**SSD-35160796 for Apsley Battery Energy Storage System ('BESS') at 9010 Mitchell Highway, Apsley (Lot 3 of DP1012686)**

20 October 2022

TfNSW has reviewed the information provided, including a Traffic Impact Assessment, prepared by *Traffic Works*, dated 30 May 2022 and the Environmental Impact Assessment, prepared by *Premise*, dated 23 August 2022, and is not satisfied that the proposed development has adequately addressed the anticipated construction traffic impact to ensure that the new access can provide safe and practical access. Accordingly, TfNSW does not support the application as proposed.

Figure 4: Indicative route for light vehicles to/from the north

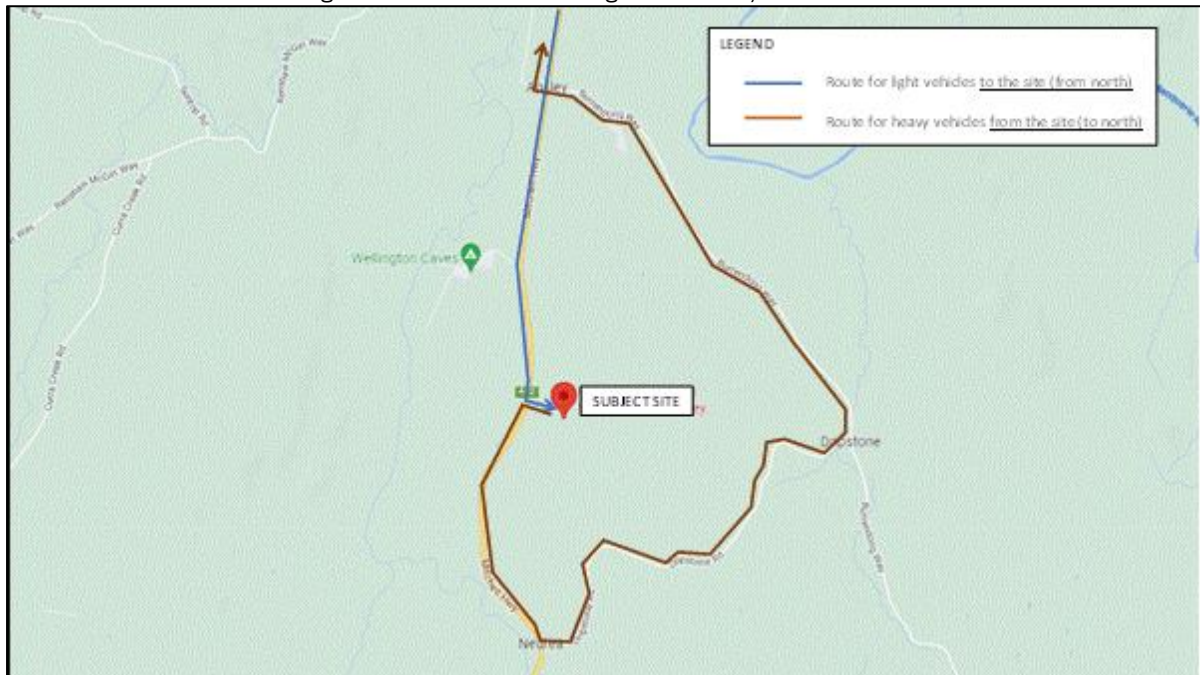
- The proposed left-in/left-out arrangement for light vehicles, as managed by a future Traffic Management Plan, is not supported. The nominated detoured route via Dripstone Road is not considered reasonable (as it more than doubles the length of time than the most direct route using a right-turn) and therefore is not a practical solution. Furthermore, Dripstone Road is a highspeed local road without line-marking or shoulders and is

Figure A1: Sight distance check plans – SISD Car and Truck, driver on a major road

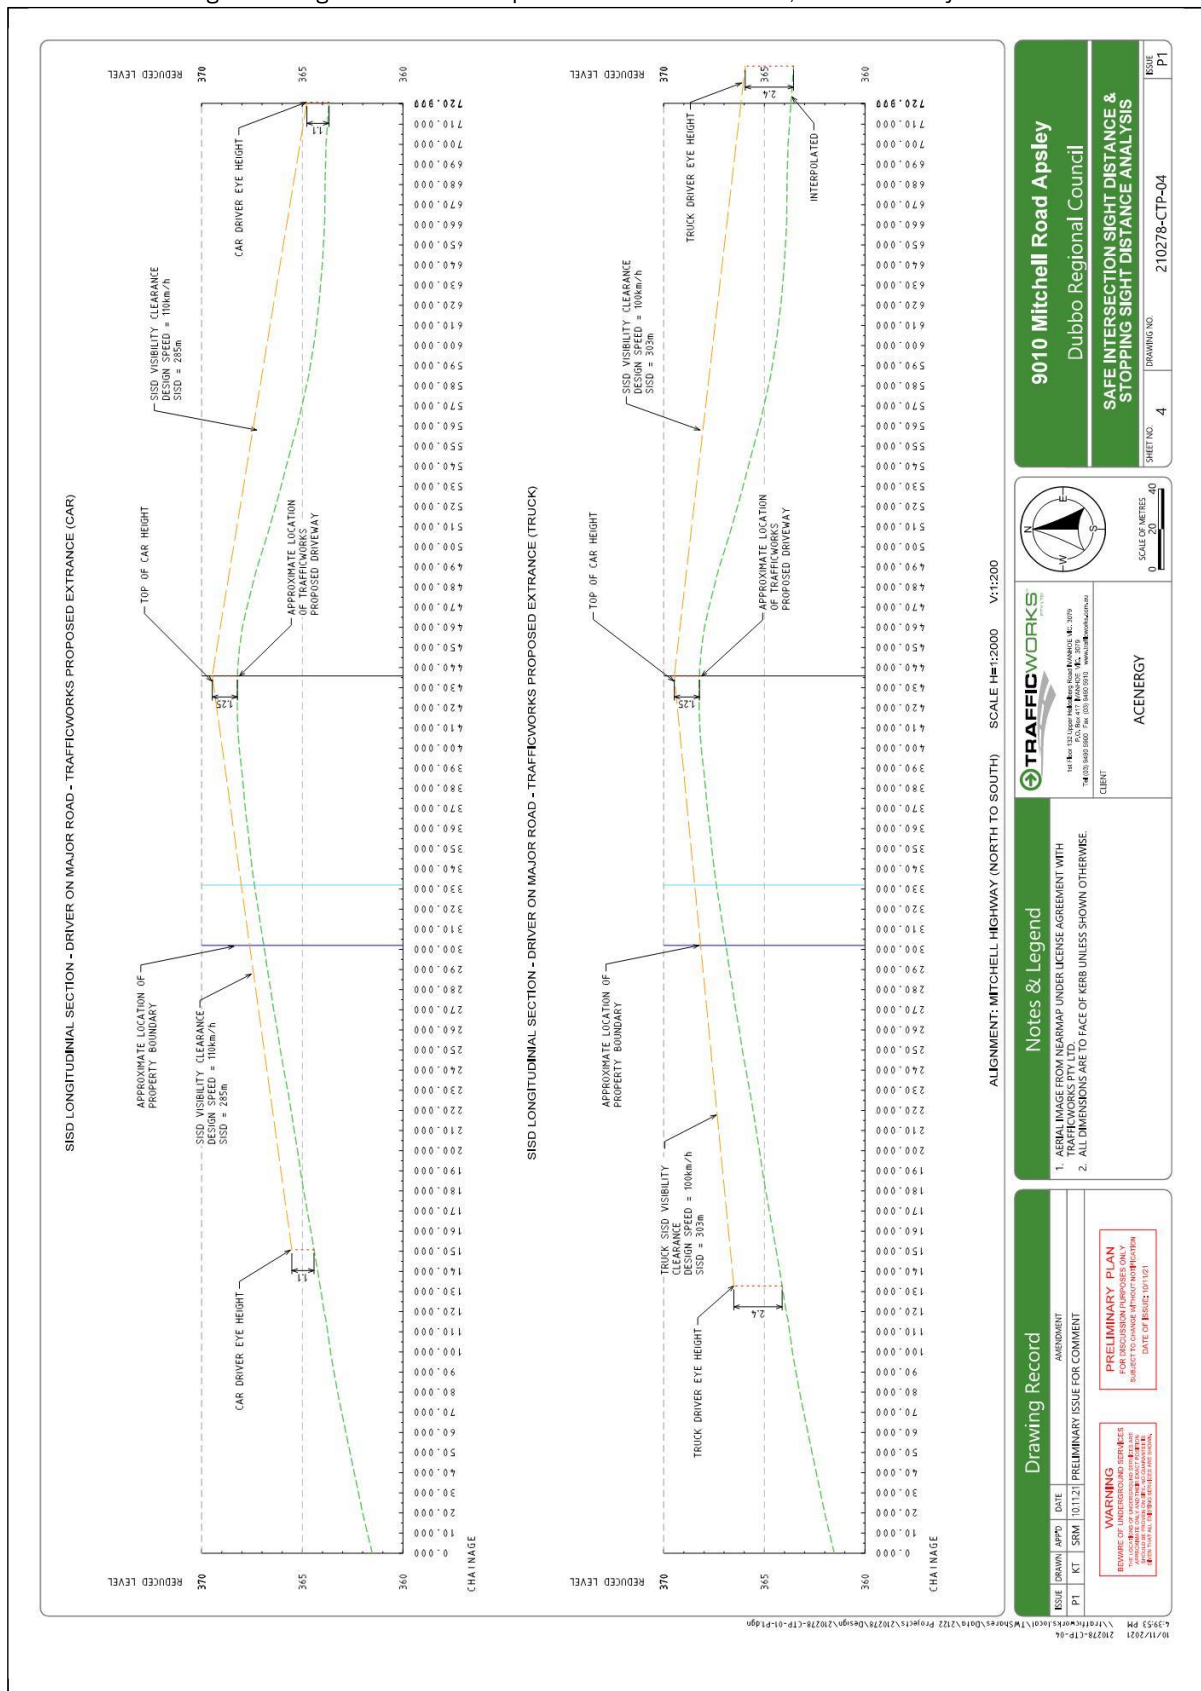
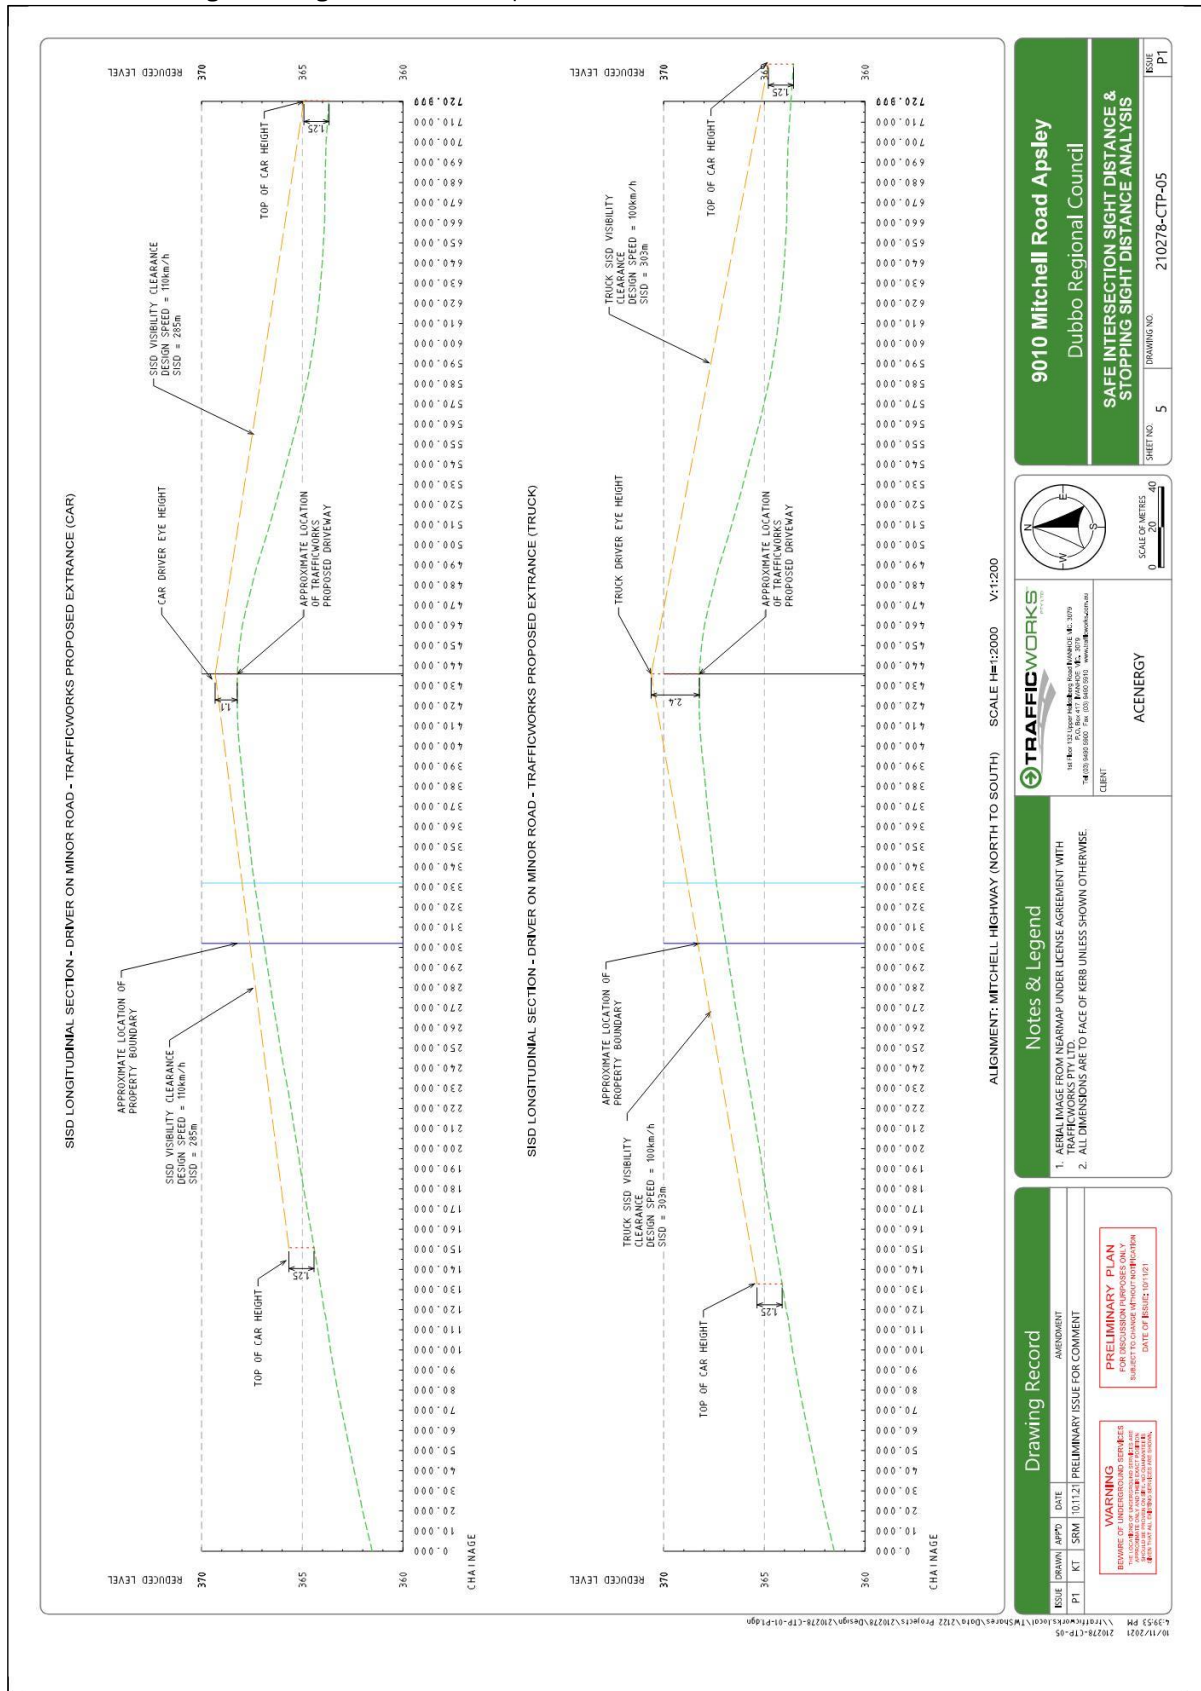
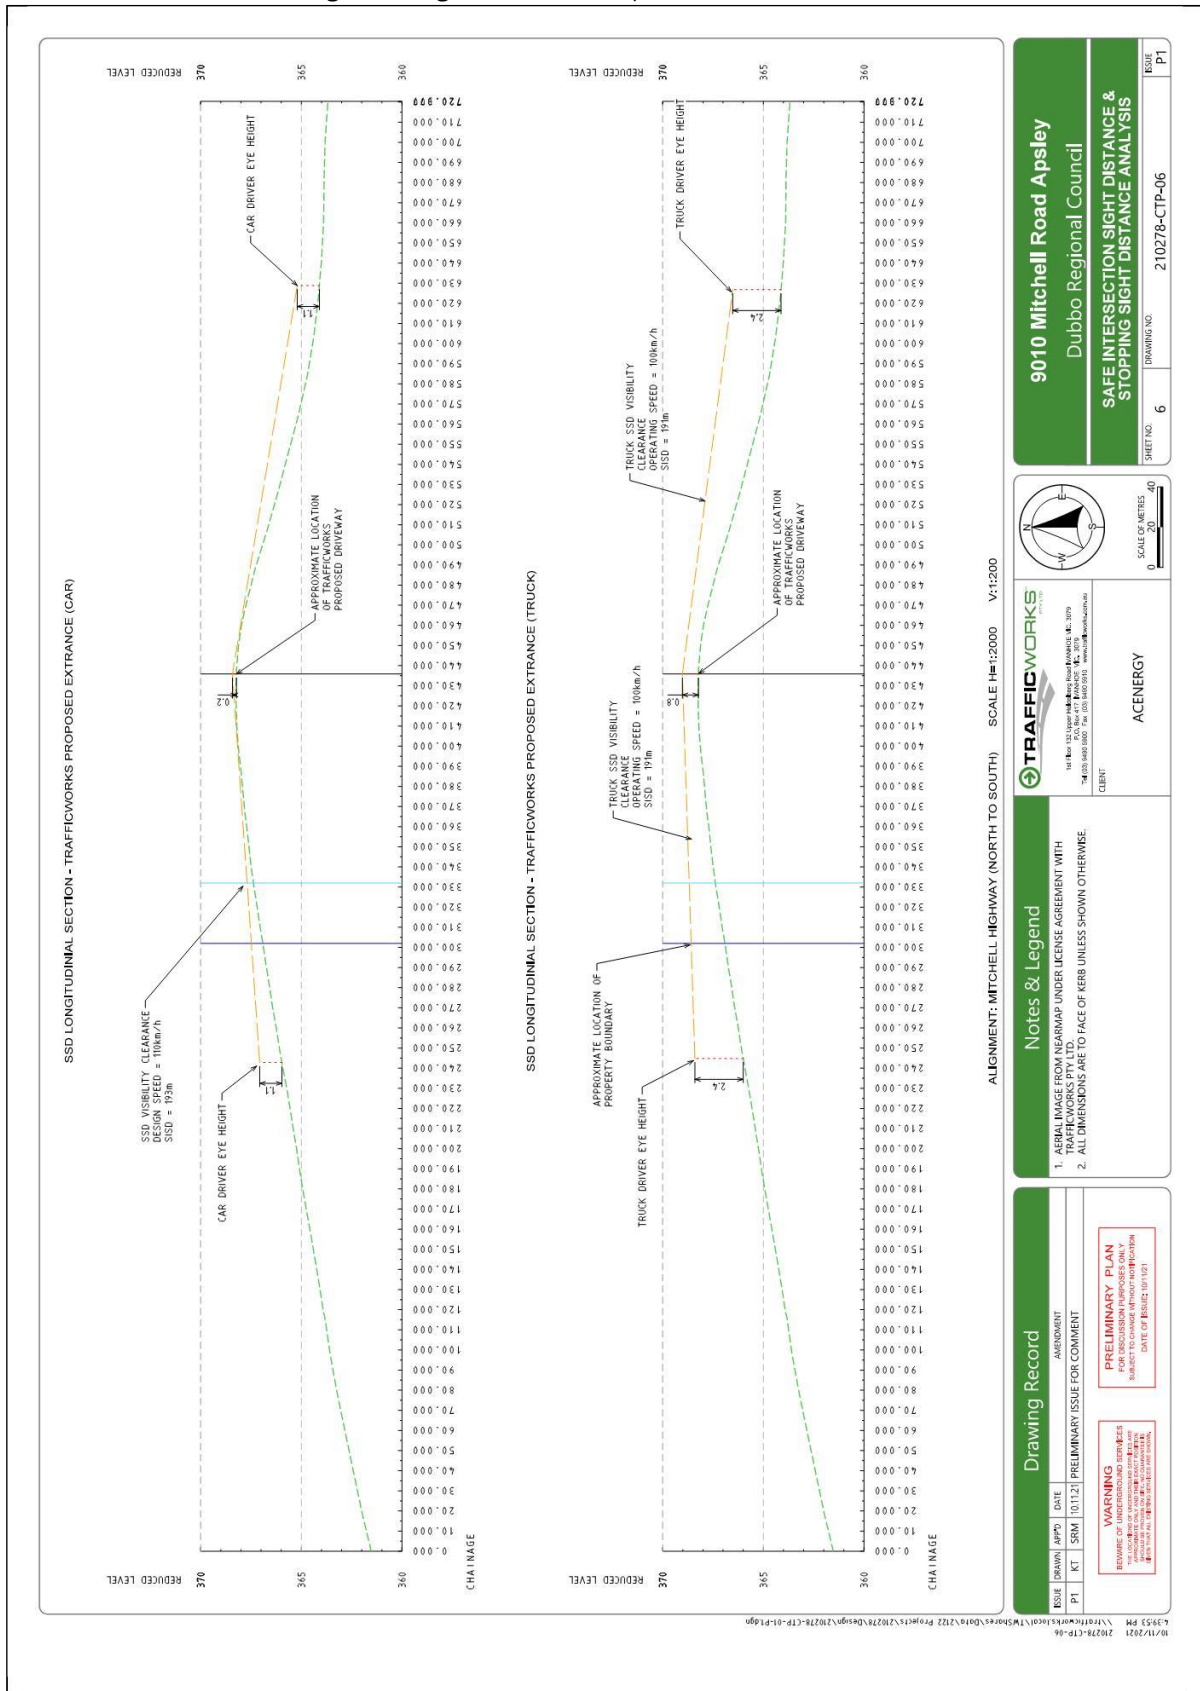
- A scaled strategic design of the proposed access addressing the above points should be provided for consideration.
- Longitudinal drawings submitted as an appendix to the Traffic are insufficient to illustrate the SISD for the proposed access location. The application should be supplemented with scaled drawings illustrating the SISD in a plan format for the design speed (being 110km/h for all vehicles) as well as a 2.5sec R<sup>t</sup> to account for traffic activity outside daylight hours or in adverse weather conditions.
